OFFICIAL NOTICE OF DECISION

CITY OF ALBUQUERQUE
PLANNING DEPARTMENT
DEVELOPMENT REVIEW BOARD

Project# 1007063

08DRB-70030 VACATION OF PUBLIC EASEMENT

Existing Site Plan
 Tracts A-1 and A-2
LLD Subdivision
 Albuquerque, Bernalillo County, New Mexico
 January 2008

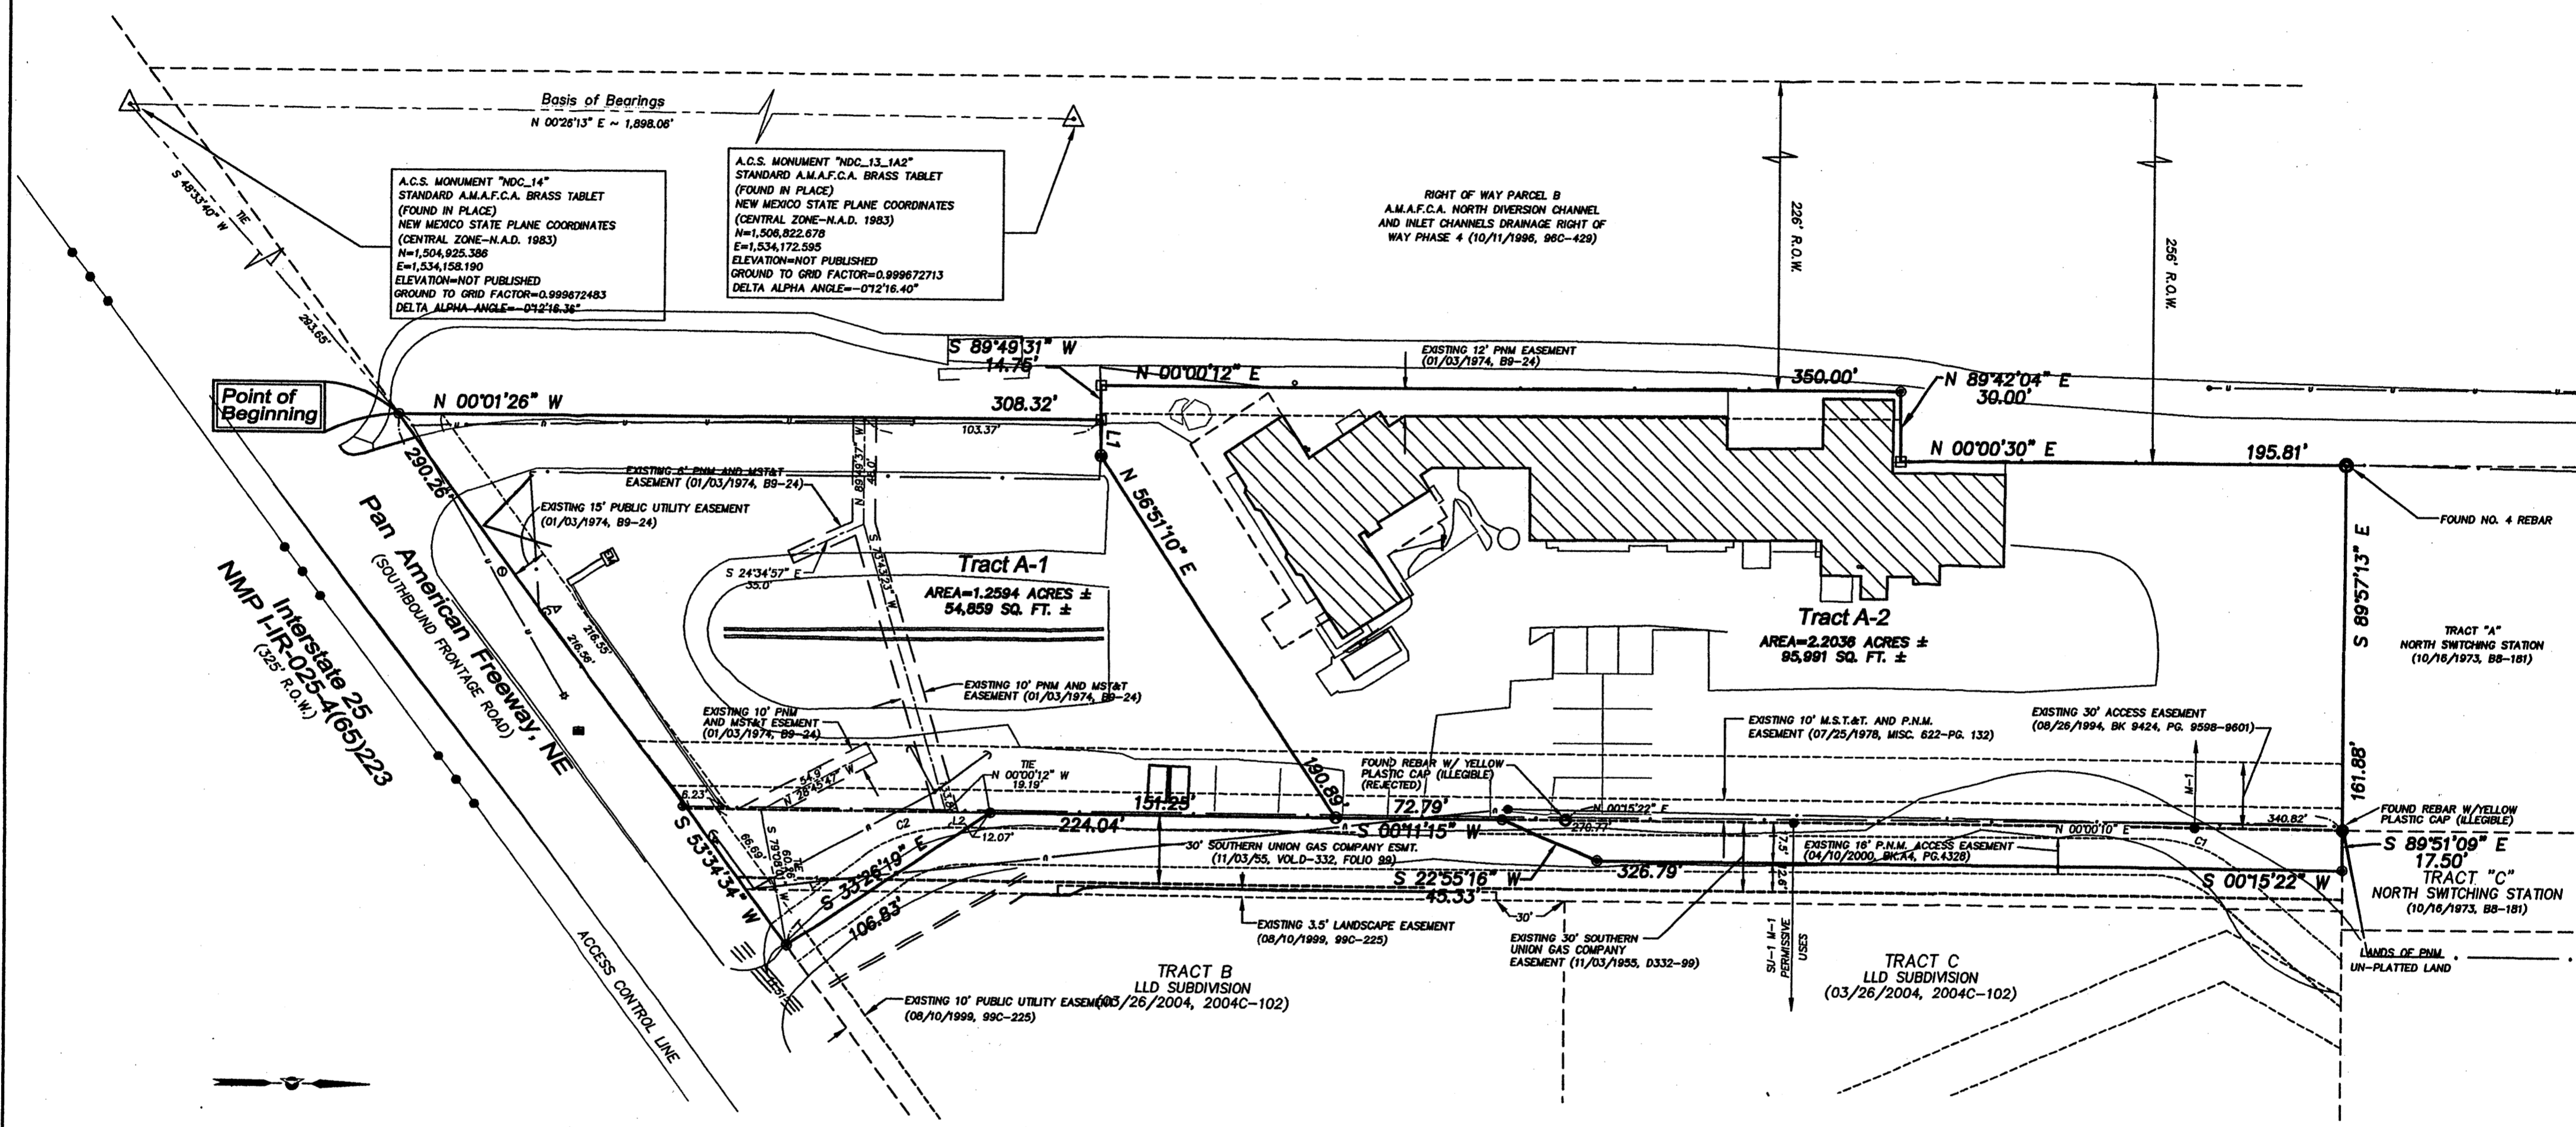
Provision of adequate on-site parking for the existing building needs to be demonstrated – per the Zoning Code: one space for each three employees on the largest shift or one space per 1,000 square feet of net leasable area, whichever requirement is greater. [§ 14-16-3-1(A)(17) OFF-STREET PARKING REGULATIONS]
